SSD7348 - MOD10 RFI RESPONSE

We refer to Penrith Council's letter, dated 13 April 2022, providing comments on SSD7348 MOD10.

**SSD7348 MOD10 – Penrith Council RFI Response, letter dated 13.04.22**

Revised Precinct 5 layout

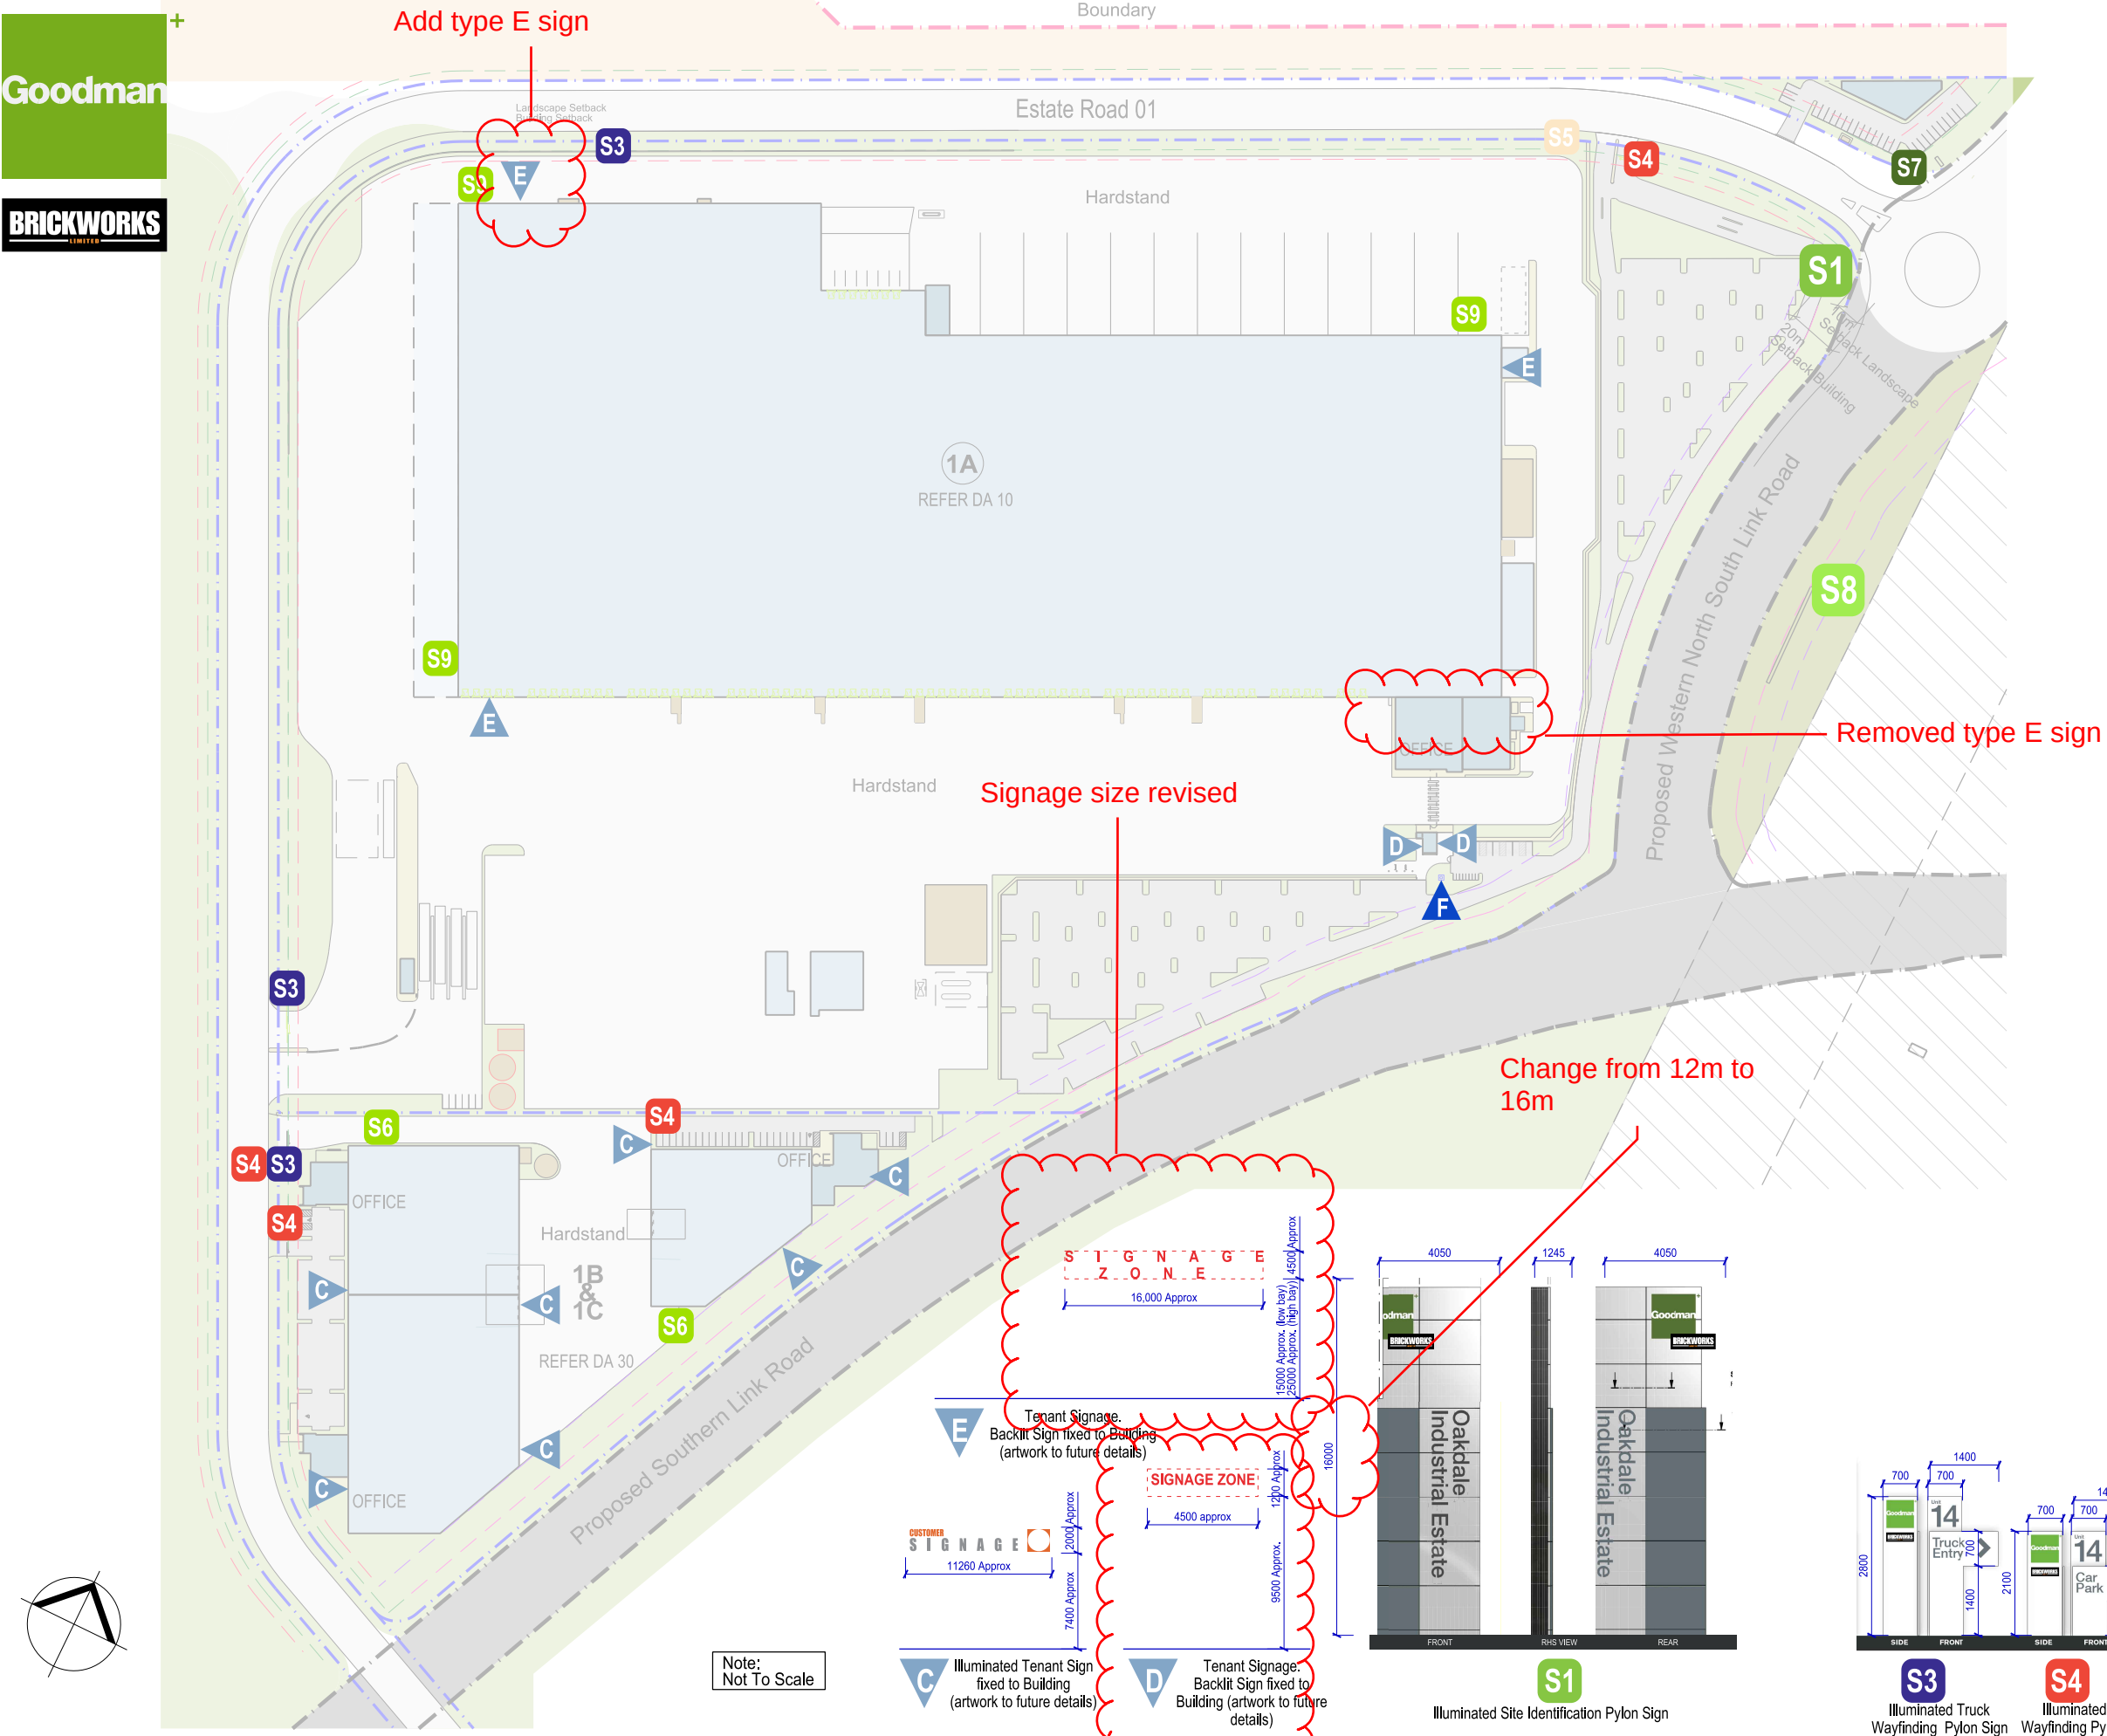
RFI		Response
<b>1</b>	<b>Planning Considerations</b>	
(d)	<p>Council objects to the site layout proposed for Warehouses 5A and 5B.</p> <p>Council strongly recommends that the Department request that the site layout be amended to provide safe and separated access from the staff and visitor parking to each office and warehouse. Future development applications for warehousing in this arrangement will not be supported by Council.</p> <p>Approval for the current layout will set an undesirable and unsafe precedence which has been avoided in the Precinct thus far.</p> <p>Staff and visitors must not be required to cross heavy vehicle driveways and manoeuvring areas. Secondary measures such as line-marking and boom gates should not be considered. Secondary measures are subject to user error and Council cannot manage compliance with consent conditions surrounding use and management of such systems.</p>	<ul style="list-style-type: none"><li>As Masterplan update (Precinct 5) removed from MOD10 application – no longer relevant.</li></ul>

<p>The access driveways and crossovers within the cul-de-sac of Tundra Close are not perpendicular to the roadway (see access for warehouse 5A2) which should not be supported.</p>	<ul style="list-style-type: none"> <li>▪ N/A - Masterplan update removed.</li> </ul>
<p>Due to the number of access points provided to each building from Tundra Close, competing, and unsupportable heavy and light vehicle manoeuvres will likely occur. Staff and visitor parking access is to be separated and located furthest from the heavy vehicle access/egress points.</p>	<ul style="list-style-type: none"> <li>▪ N/A - Masterplan update removed.</li> </ul>
<p>Tundra Close could be extend toward east to provide sufficient and safe separated heavy vehicle access.</p>	<ul style="list-style-type: none"> <li>▪ N/A - Masterplan update removed.</li> </ul>
<p>Strong consideration shall be given to requiring shared truck entry and exit point for the two warehouses. Warehouse 5A1 could also be rotated 90 degrees clockwise to separate access.</p>	<ul style="list-style-type: none"> <li>▪ N/A - Masterplan update removed.</li> </ul>

<p>Warehouse 5A2 is not provided with separated entry and exit points for heavy vehicles. It has not been made clear from plans provided, that a conflict will not arise when entering and exiting heavy vehicles meet on this same driveway. Separate entry and access points for heavy vehicles are to be provided for 5A2.</p>	<ul style="list-style-type: none"> <li>▪ N/A - Masterplan update removed.</li> </ul>
<p>The current arrangement of entry and exit points in the cul-de-sac and location and design of truck manoeuvring/driveways and staff parking and access points should not be supported and must be re-designed.</p>	<ul style="list-style-type: none"> <li>▪ N/A - Masterplan update removed.</li> </ul>
<p>Should this warehouse be split into two and operated by separate tenants, the rear (northern) portion of the warehouse will need to be provided with staff and visitor parking which does not require pedestrians to traverse areas of hardstand which are utilised by</p>	<ul style="list-style-type: none"> <li>▪ N/A - Masterplan update removed.</li> </ul>

heavy vehicles and which does not require excessively long paths of travel.	
The layout would need to be amended to provide separated heavy vehicle, and staff and visitor access points.	<ul style="list-style-type: none"> <li>▪ N/A - Masterplan update removed.</li> </ul>
Warehouse buildings including gatehouse structures are to be provided with easily accessible and convenient amenities and staff areas. It is noted that the second gatehouse and dock office (north elevation of Warehouse 5A) is relatively isolated from the office amenities and that any additional warehouse amenities are not indicated.	<ul style="list-style-type: none"> <li>▪ N/A - Masterplan update removed.</li> </ul>
<b>(e) Signage</b>	
No objections are raised to the reduction in scale of building identification signs “D” and “E” or to the requisite signage zones.	<ul style="list-style-type: none"> <li>▪ Noted.</li> </ul>
<p>Section 2.1.3 and Section 3.2 of the applicant’s statement do not clarify the proposed final height of the approved pole sign and it is assumed that the proposal is to increase the height of the pole sign by 4m.</p> <p>Pole signage shall not be raised in height. The additional height is not required to assist in brand advertising or wayfinding. An increase in height to match the bulk or scale of the building is not adequate justification and will set an undesirable precedence.</p>	<ul style="list-style-type: none"> <li>▪ The proposed 16m high pylon sign is considered appropriately scaled when considering contextually against the adjacent 36m high host building;</li> <li>▪ The signage is not used for advertising, but rather important ‘building’ and ‘business’ identification.</li> <li>▪ The proposal will not set an undesirable precedent as more recessively sized entry signage would be appropriate in alternative precincts where standard warehouses (13.7m ridge height) are proposed.</li> <li>▪ The proposed pylon sign is located away from any sensitive receivers.</li> </ul>

(g)	The proposed modification seeks a total of five (5) driveways accessing the site from the cul-de-sac. Heavy vehicle movements will conflict with staff and visitor car parking movements within the cul-de-sac, which is not supported.	<ul style="list-style-type: none"> <li>▪ N/A - Masterplan update removed.</li> </ul>
	Safety concerns are raised for the location of the staff car park for Warehouse 5A1 as pedestrians will be required to cross the heavy vehicle driveway to access the building which is not supported. The previously approved Masterplan for Precinct 5 had separated the heavy vehicle areas from the staff car parking areas. The use of a boom gate and traffic signal system is not supported.	<ul style="list-style-type: none"> <li>▪ N/A - Masterplan update removed.</li> </ul>

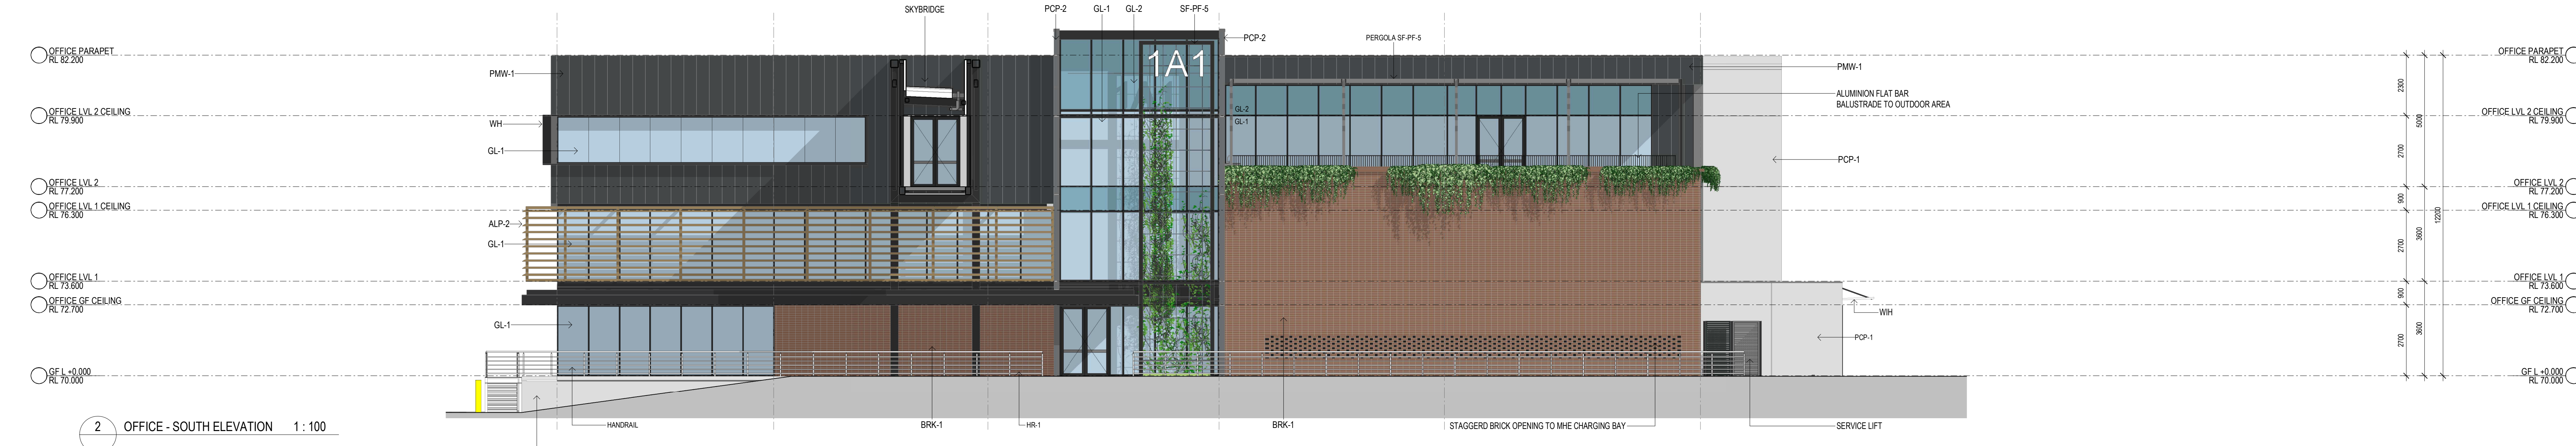
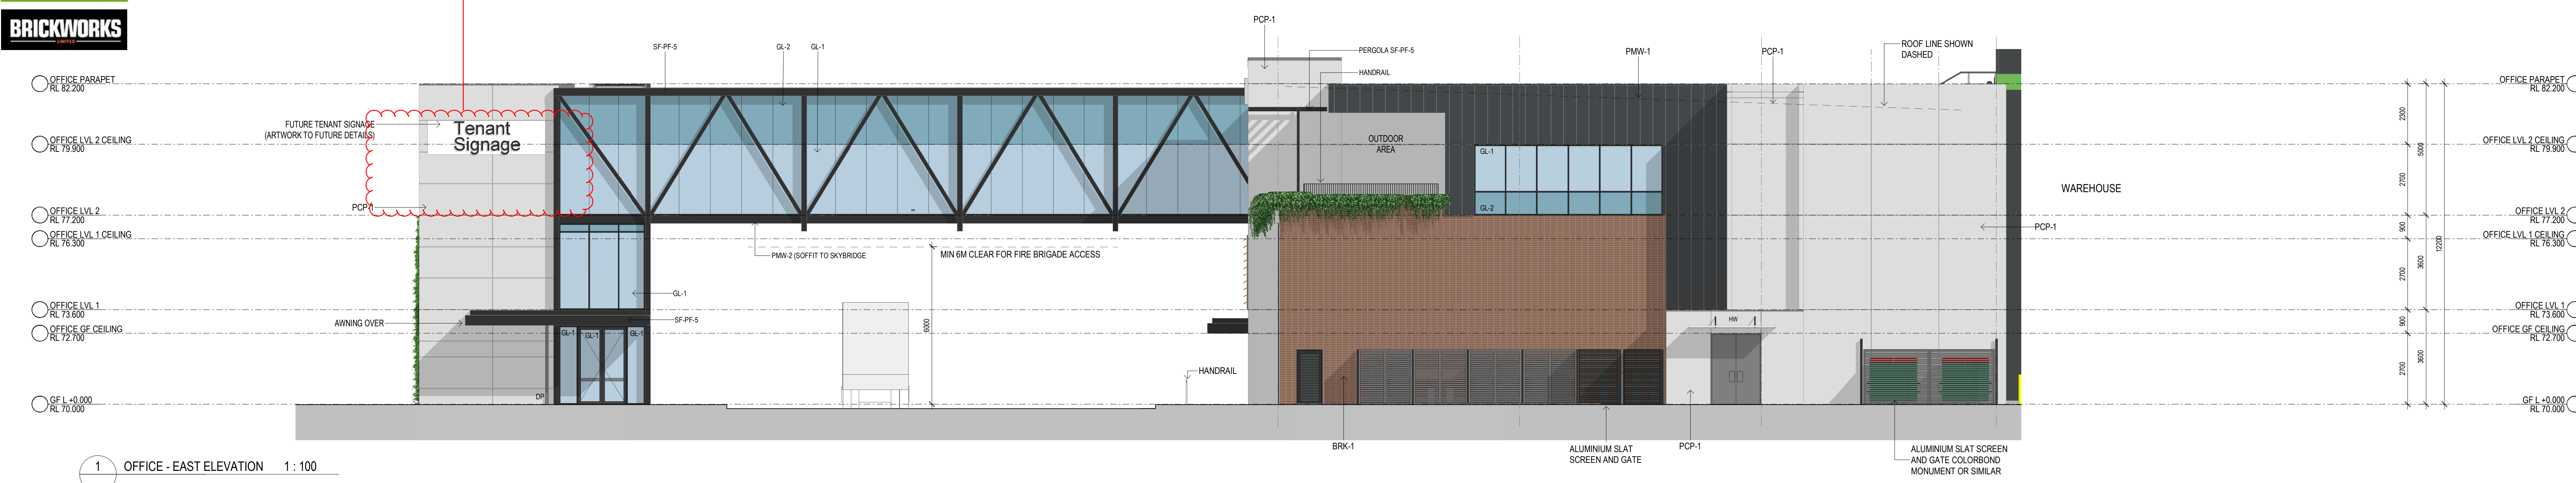
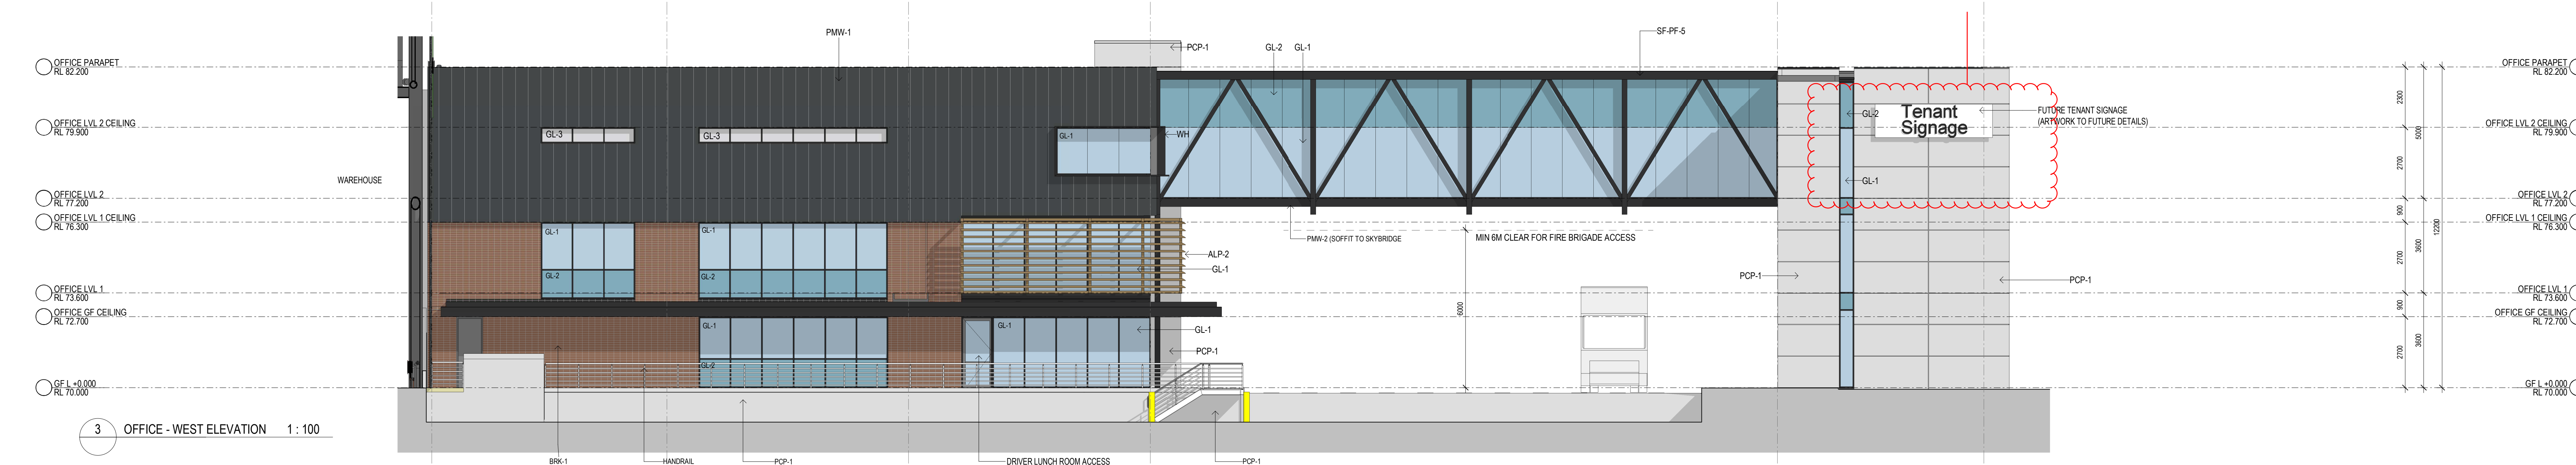
<p>The proposal to increase signage height does not comply with the DCP requirements for signs in the Estate (Section C9 and E6 of the Penrith DCP) which require the height of pole signs to be no greater than 7m.</p>	<ul style="list-style-type: none"> <li>▪ As SSD7348 is State Significant Development, the Penrith DCP's 7m signage height control does not apply to the proposal and not therefore relevant to the assessment.</li> </ul>
<p>The proposal to raise the height of the pole sign is contrary to the objectives and matters for consideration under SEPP (Industry and Employment) 2021 – Chapter 3, Schedule 5 as the signage is:</p> <ul style="list-style-type: none"> <li>- not compatible with the desired future character of the area (as is set by the limiting of pole signs to 7m under the DCP) and,</li> <li>- will detract from the amenity and visual quality of the area, will have a dominating effect, and</li> <li>- the scale is not appropriate for the streetscape, setting and landscape, and</li> <li>- will not contribute positively to the streetscape,</li> <li>- does not reduce clutter, screen unsightliness, or provide visual interest, and</li> <li>- will protrude above nearby canopy.</li> </ul>	<ul style="list-style-type: none"> <li>▪ Goodman disagrees that the proposal is not compatible with Schedule 5 of SEPP (Industry and Employment) 2021 - refer to assessment of the proposal against Schedule 5, included in SEE. In particular: <ul style="list-style-type: none"> <li>– The signage is appropriately scaled to respond to the significant scale of adjacent industrial built form, which characterises the area.</li> <li>– It is not agreed that the signage will detract from the visual quality of the area and not contribute positively to the streetscape. It will provide an appropriately scaled entry sign to match that of the Oakdale West Estate precinct.</li> <li>– The proposed pylon entry sign will not have a 'dominating effect' when viewed contextually against the significant adjacent warehouses.</li> <li>– The proposed S1 sign is the only one of its kind proposed for the entire Oakdale West Estate precinct. As the S1 sign has already been approved for this location and with the same width, it is not agreed that the additional 4m of height will result in additional or unacceptable visual clutter.</li> <li>– It is argued that the scale of the sign will provide visual interest, providing suitable announcement of Oakdale West Estate at this key gateway location on entering the precinct.</li> <li>– Given that the purpose of the signage is to identify the Oakdale West precinct, it is considered necessary to be of a</li> </ul> </li> </ul>

scale to necessarily protrude above the nearby canopy, and not be obscured by it.
(f)	<b>Gross floor area (GFA)</b>	
	No objection is raised in relation to Precinct gross floor area increase, noting that the overall OWE GFA remains as approved.	<ul style="list-style-type: none"> <li>▪ Noted.</li> </ul>
<b>2</b>	<b>Development Engineering Considerations</b>
